Our Case Number: ABP-317742-23

Re: BusConnects Bray to City Centre Core Bus Corridor Scheme
Bray to Dublin City Centre.

BRAY TO CITY CENTRE CORE BUS CORRIDOR SCHEME

Strategic Infrastructure Development Application

Image 3.13: Section 3 Route Options Remaining After Stage 1 Sifting (Bray to UCD CBC Feasibility and Options Report (NTA 2017))

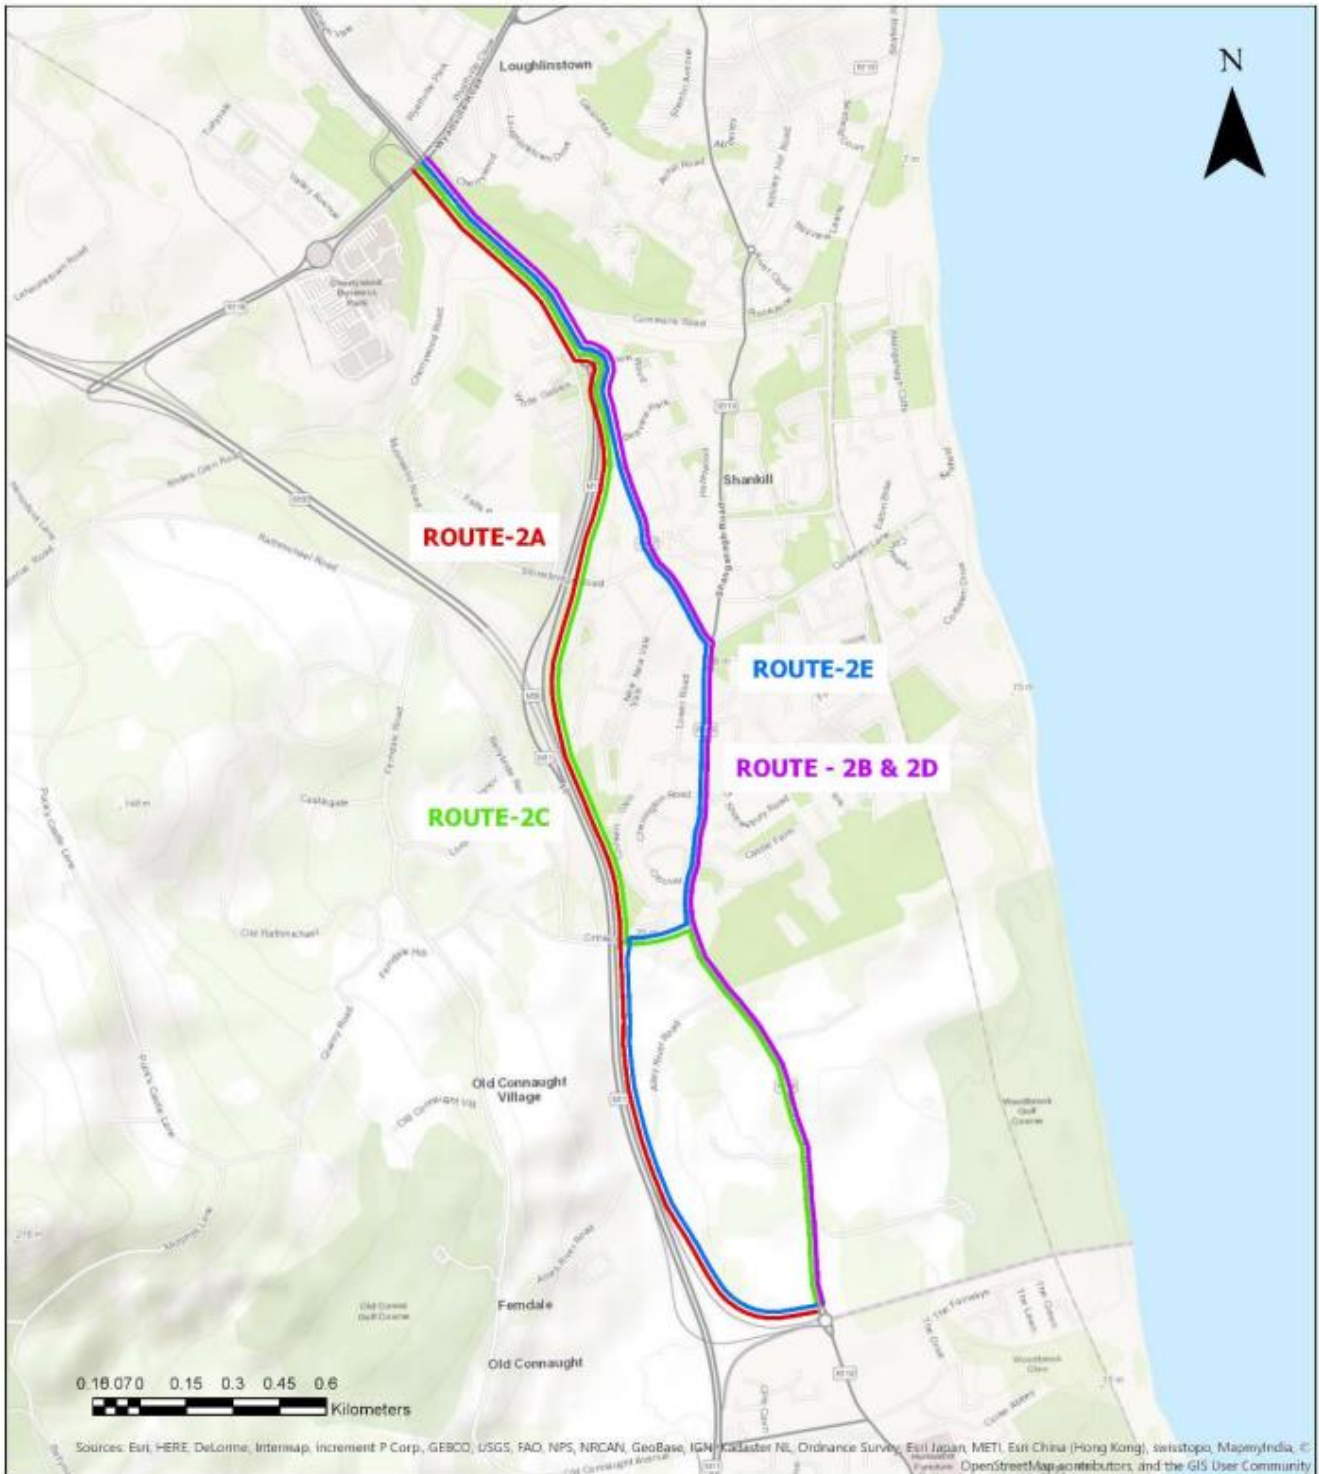
The Feasibility and Options Report identifies a number of route options, including the chosen route along the existing R119 / R837 through Shankill Village between Wilford and Loughlinstown Roundabouts (Route Option 2B). An alternative route running to the east and outside of the M11 corridor (Route Option 2A) was also considered as were combinations of these two routes.

I wish to focus on Route Option 2A. I contend that Route 2A was never a viable option. The proposed alignment on the eastern side of the M11 coincides with the proposed alignment for the future extension of the Luas Green Line from Brides Glen to Bray, as set out in the Bray and Environs Transport Study 2019, see Fig 1. This alignment is confirmed in the Dun Laoghaire-Rathdown County Development Plan, see Fig 2.

South of Crinken Lane bridge, there is generally adequate space to accommodate the future Luas Line and a dedicated two way bus lane with cycle track provision. However, north of the Lordello Road footbridge this is not the case. There are pinch points at Newvale and at Stonebridge Close between Lordello Road footbridge and Stonebridge Road. There are further pinch points north of Stonebridge Road at Stonebridge Wood and Newbank.

Allowing a bare minimum of 3m for each bus lane and Luas track, consistent with the cross section for the dedicated busway presented in the Feasibility document and allowing 1.5m edge distance gives an absolute minimum reservation width of 15m. Whatever about being able to avail of lands within the current motorway reservation adjacent to Stonebridge Close, it would not be possible to accommodate this width of reservation for both Luas and Busconnects at the corner of Newvale, at Stonebridge Wood and at Newbank. In the case of the latter two locations, a number of recently constructed houses would have to be demolished. Of course, this could be done – but none of this was referenced in either the Feasibility and Options Report or in Chapter 03 of the EIAR –

Consideration of Reasonable Alternatives. Although the EIA Directive does not require a mini-EIA for each of the alternatives presented, it surely does require that the options tabled are at least viable and that all principal relevant constraints have been identified. This has not been done in the case of Options 2A, 2C and 2D and none of these Options is therefore viable or valid.

Image 3.15: Alternative Cycle Route Options Through Shankill (Bray to UCD CBC Feasibility and Options Report (NTA 2017))

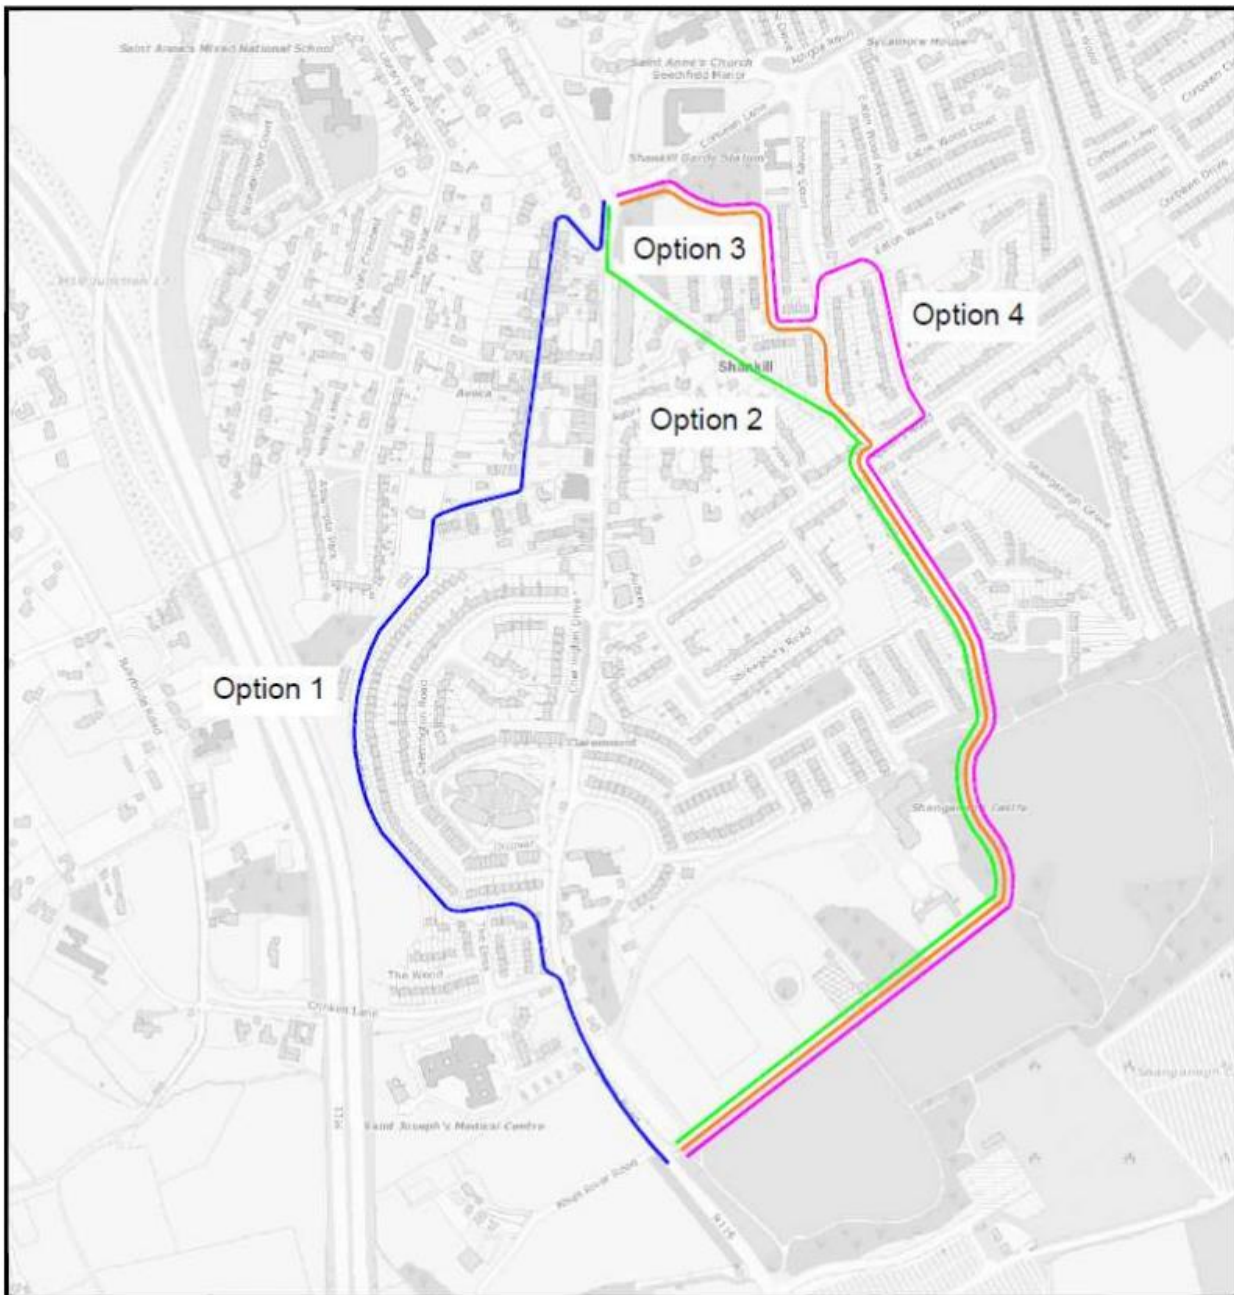
This indicates that from Crinken Lane to St. Anne's Church, chosen Option 3 includes a northbound bus lane from Crinken Lane to Quinns Road, with a section of northbound bus lane through Shankill Village between Stonebridge Close and Lower Road and a southbound bus lane between Lower Road and Crinken Lane. This contradicts the photomontage images taken between Crinken Lane and Quinns Road (Fig 6) and opposite Stonebridge Close (Fig 7). I would be happy if the Photomontages represent the correct position – but which are people to believe?
